COUNCILLOR FRANK MARSH'S POINTS ON BEHALF OF RESIDENTS RE: CAMPUS WEST CAR PARK REDEVELOPMENT

APPLICATION NUMBER 6/2021/2207/MAJ

### 1.1.3 Result overview, Spill lighting north

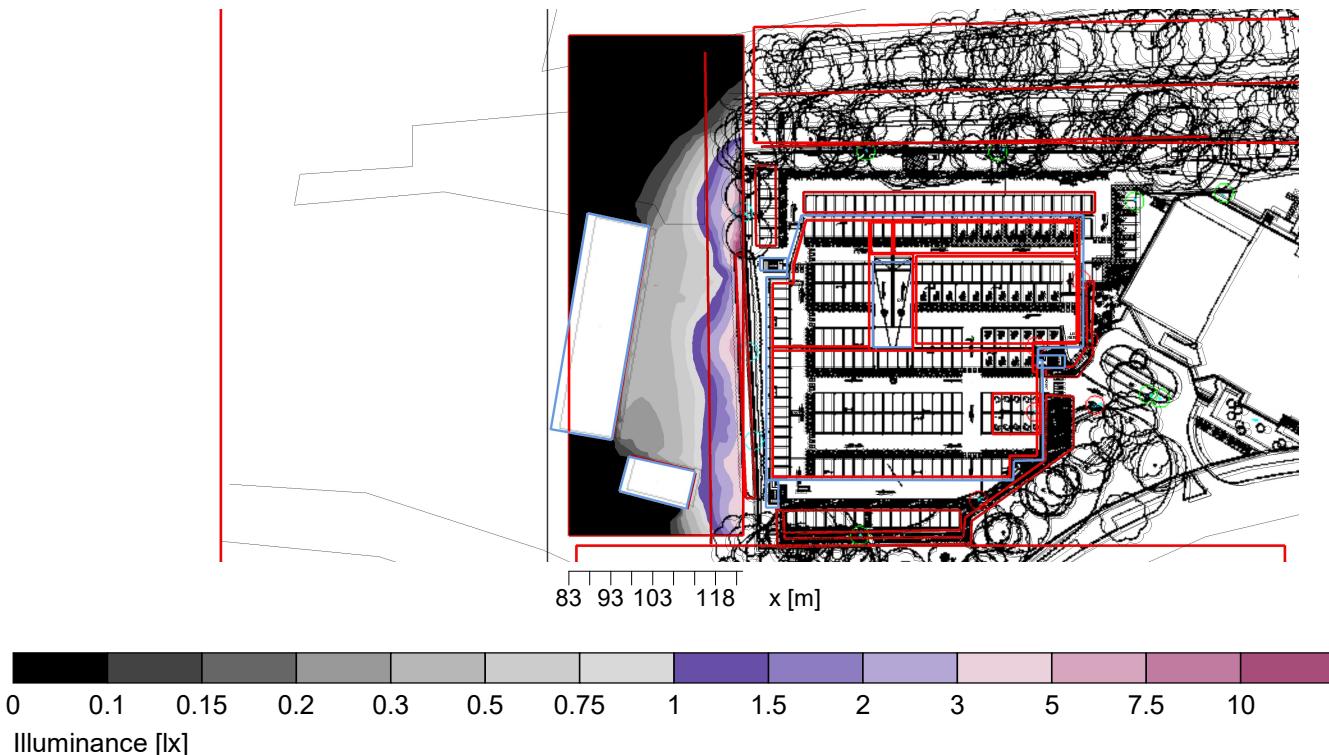
1. **The lighting on the top deck is too prominent** - The carpark should have low level lighting on the top deck within the external barrier walls and it should be dimmed all the time that they are on. There should be no lighting on polls or anything like flood lighting. All lighting should be dimmed lighting, so it does not shine into homes. It should be a condition that the lighting curfew outlined in the report is implemented ie that lights should be dimmed between 23.00 – 6.00.

3. **There is insufficient cladding on the northern elevation to reduce noise, light and air pollution** - The cladding on the northern elevation should create a solid wall extending 3 metres above the top deck surface level so preventing light, noise and air pollution from impacting upon local homes. This could be a 'green wall' or red brick wall with architectural features just like the Hatfield Station carpark.
